Our Ref: BN/81/20/DOC

Approval of details reserved by condition imposed under ref BN/121/19/PL relating to Condition Nos 3 - surface water drainage, 4 - Construction Management Plan, 5 - materials & finishes, 6 - hard & soft landscaping, 7 - drainage scheme, 8 - storage of waste and 13 - renewable energy.

Swallowfield Eastergate Lane Eastergate PO20 3SJ

Revision:			
address Swallowfield, Eastergate Lane Eastergate, PO20 3SJ			
project Proposed construction of detached chalet bungalow			
title Proposed Surface Drainage			
scale 1:500 @A4	date May 2020	dwg no 2019.257DRA	revision

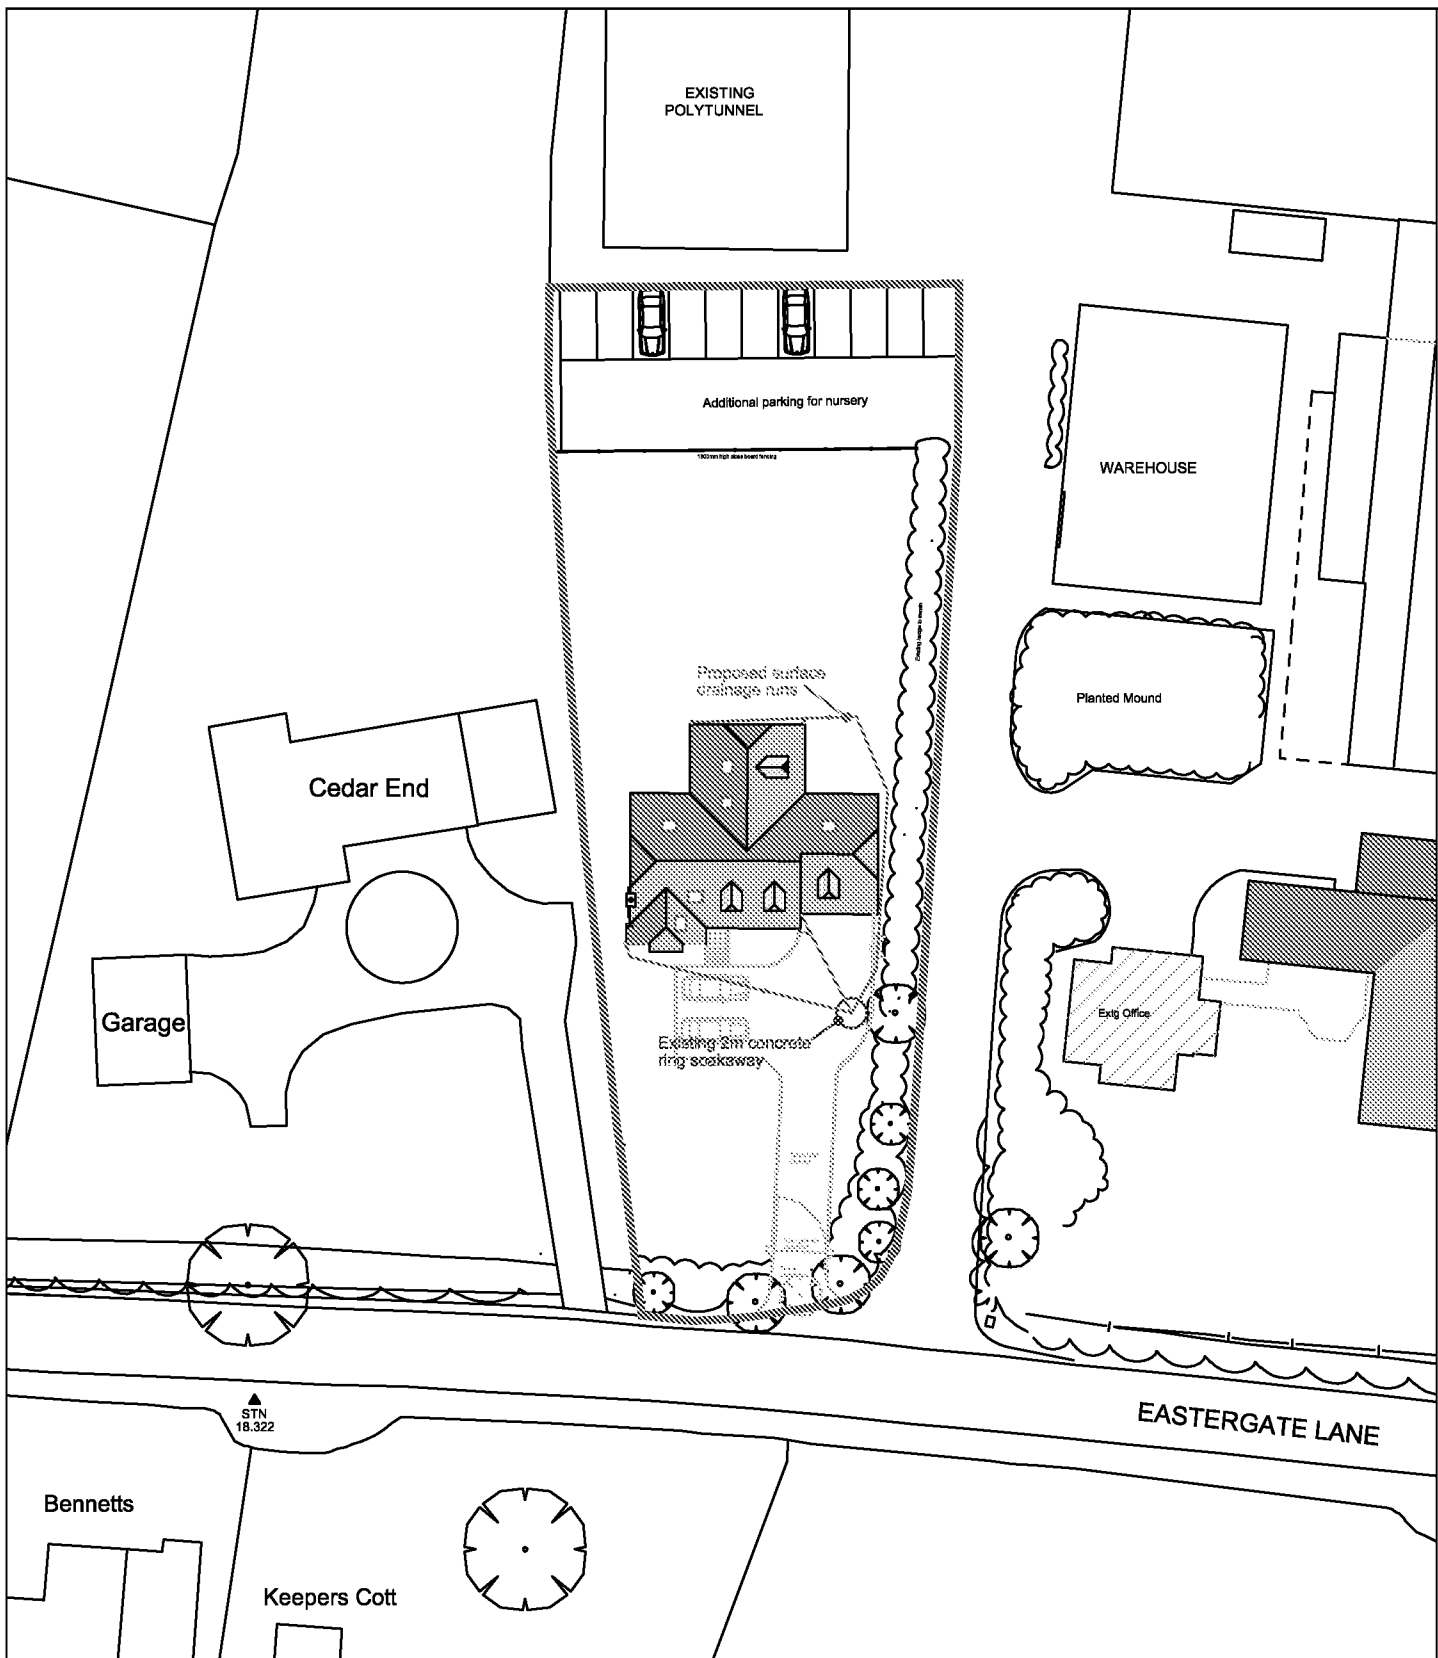
Arun District Council have decided to **REFUSE details reserved by condition for the following reasons:** Council Drainage Engineers have objected to the discharge of this condition on the grounds that the information supplied is insufficient to recommend discharge of condition 7 on application BN/121/19/PL.

As such, the condition cannot be discharged and you will need to make a revised submission.
